July 25, 2025

**Re: Hope Charter School at 5310 Sequoia Rd NW
Erosion and Sediment Control Plan
Engineer's Stamp Date - missing - G11E048 (SWQ-2025-00041)**

James D. Hughes, P.E., CPESC
Principal Engineer, Planning Dept.
Development and Review Services

CODE LANDSCAPE PLAN

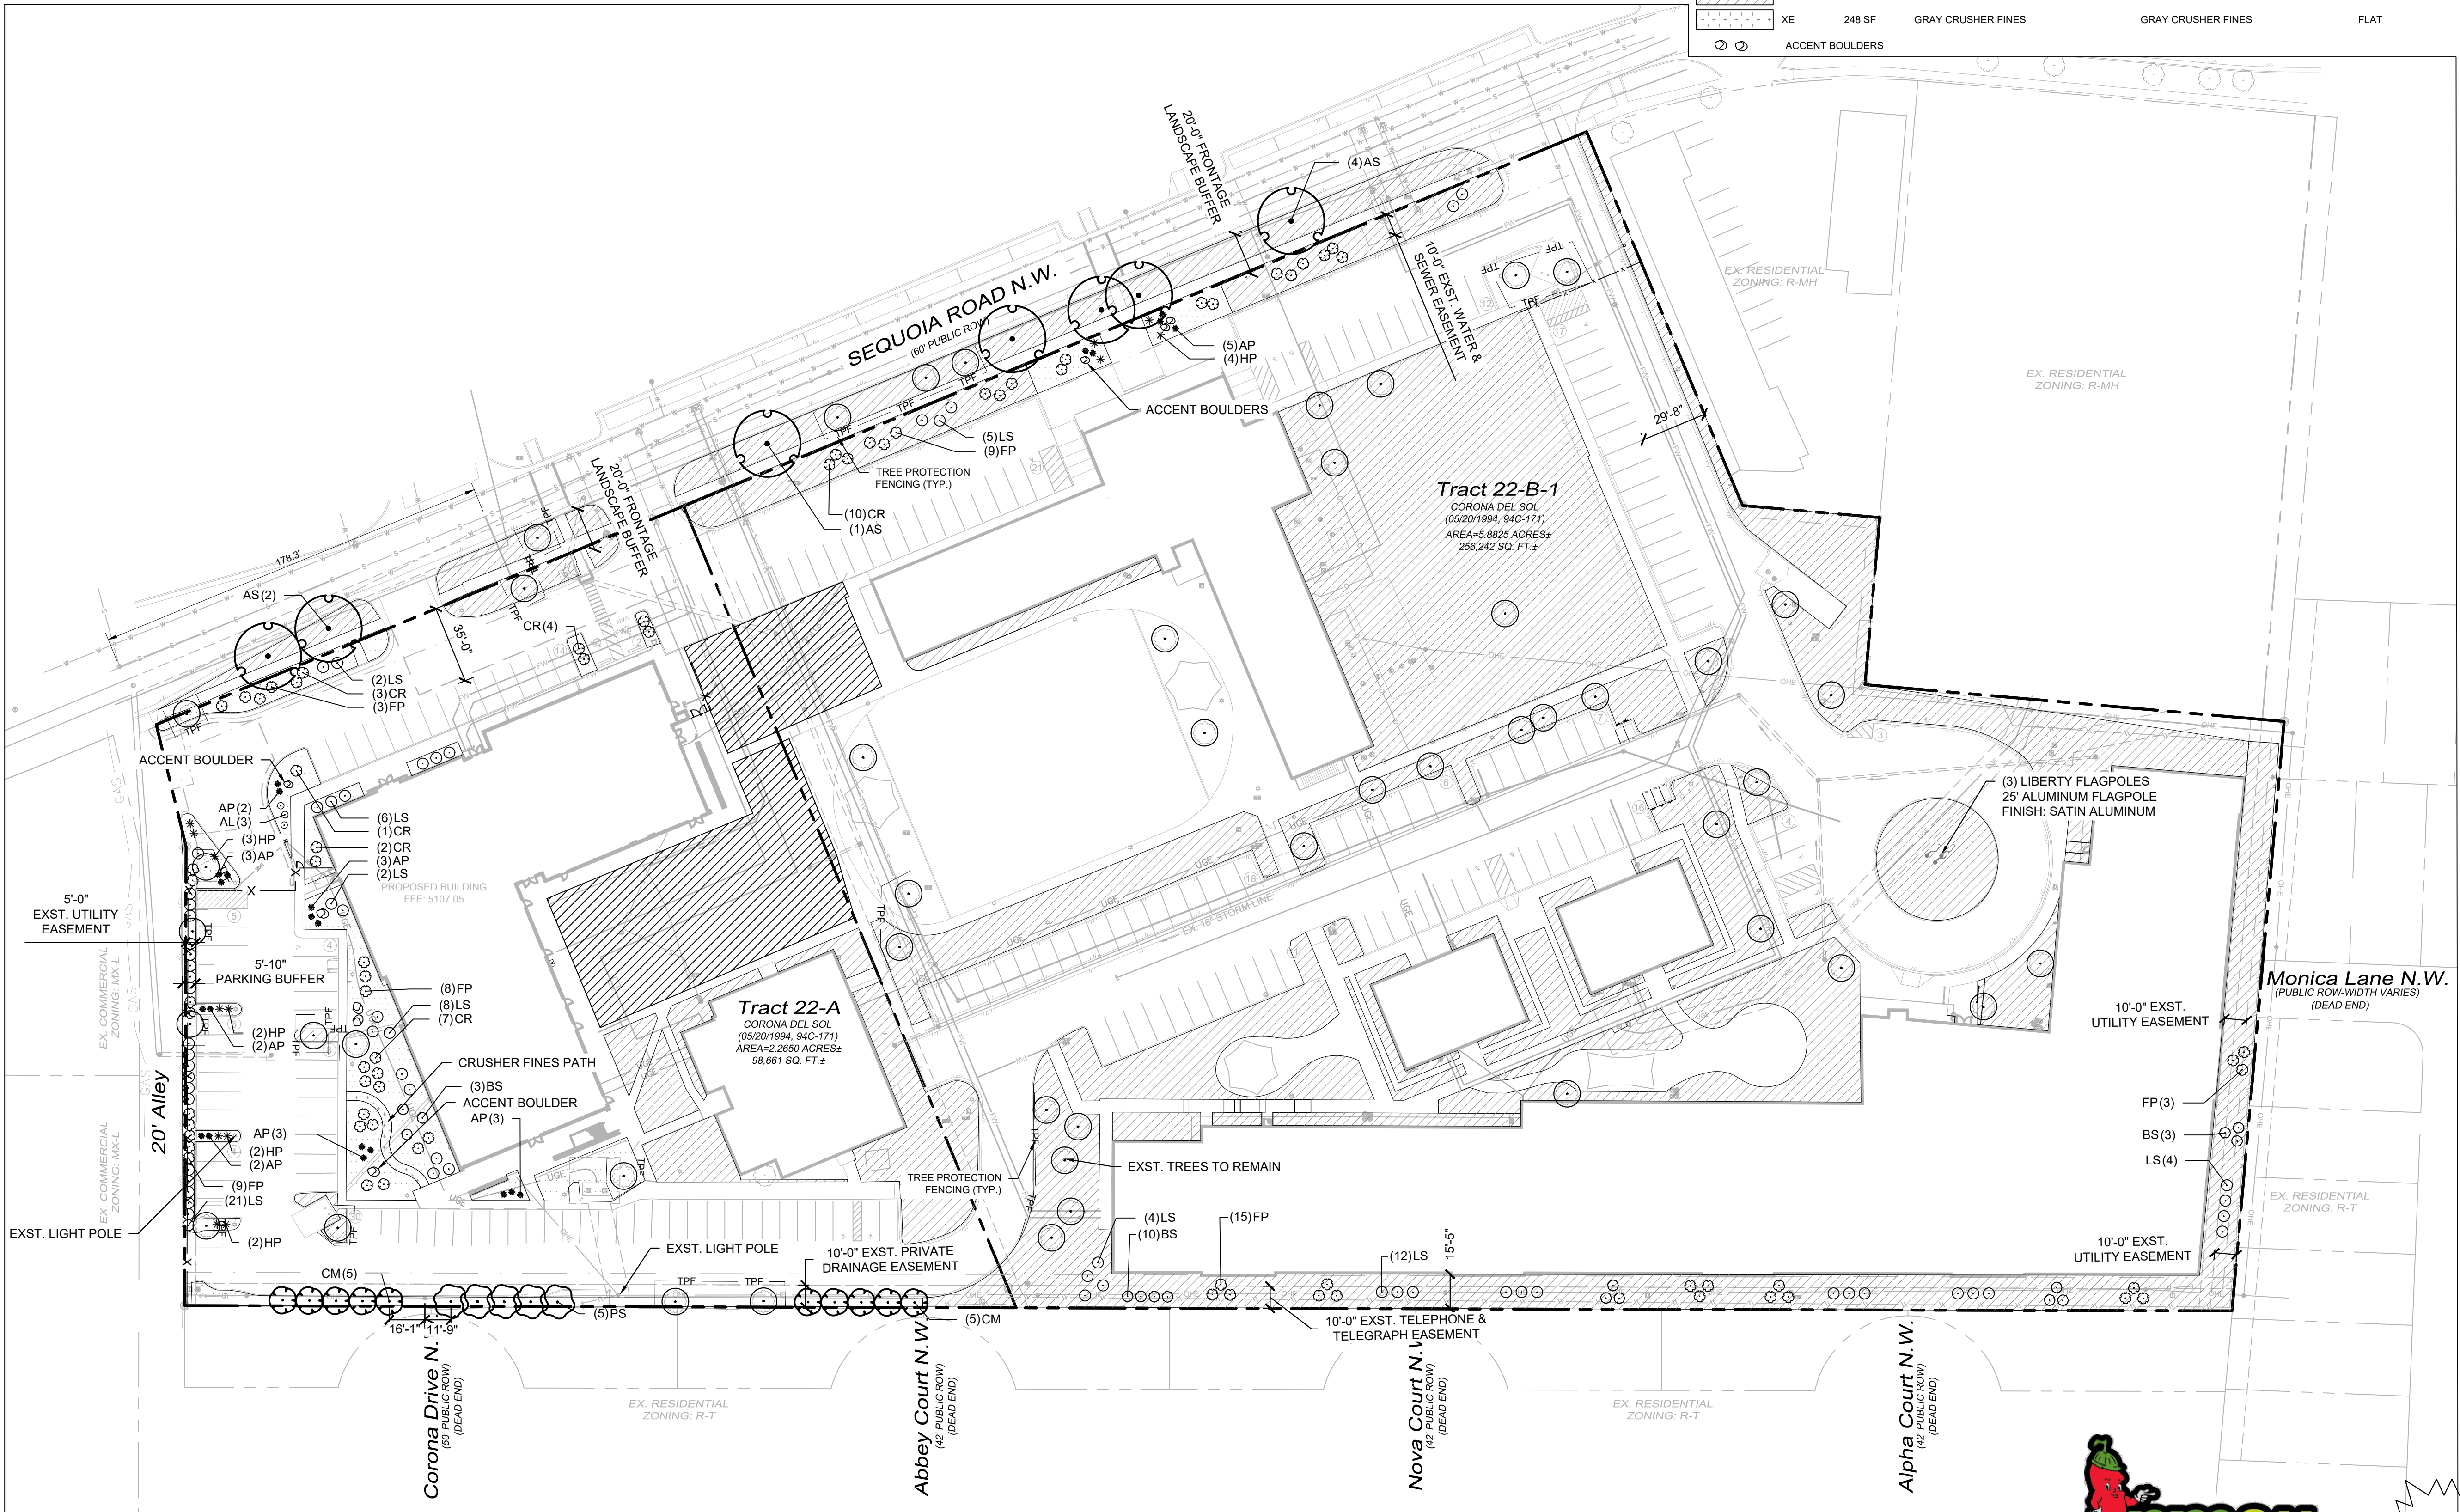
4. Some parts of this 8-acre site are already disturbed. Stabilization measures (CGP 7.2.6.b.vi) must be identified, including specific vegetative and non-vegetative practices and deadlines. The landscape plan can be used to meet this requirement and should be included (on sheets separate from the ESC Plan) in the SWPPP and the ESC Plan submittal. Erosion and sediment controls are required in all disturbed areas, including landscaping.
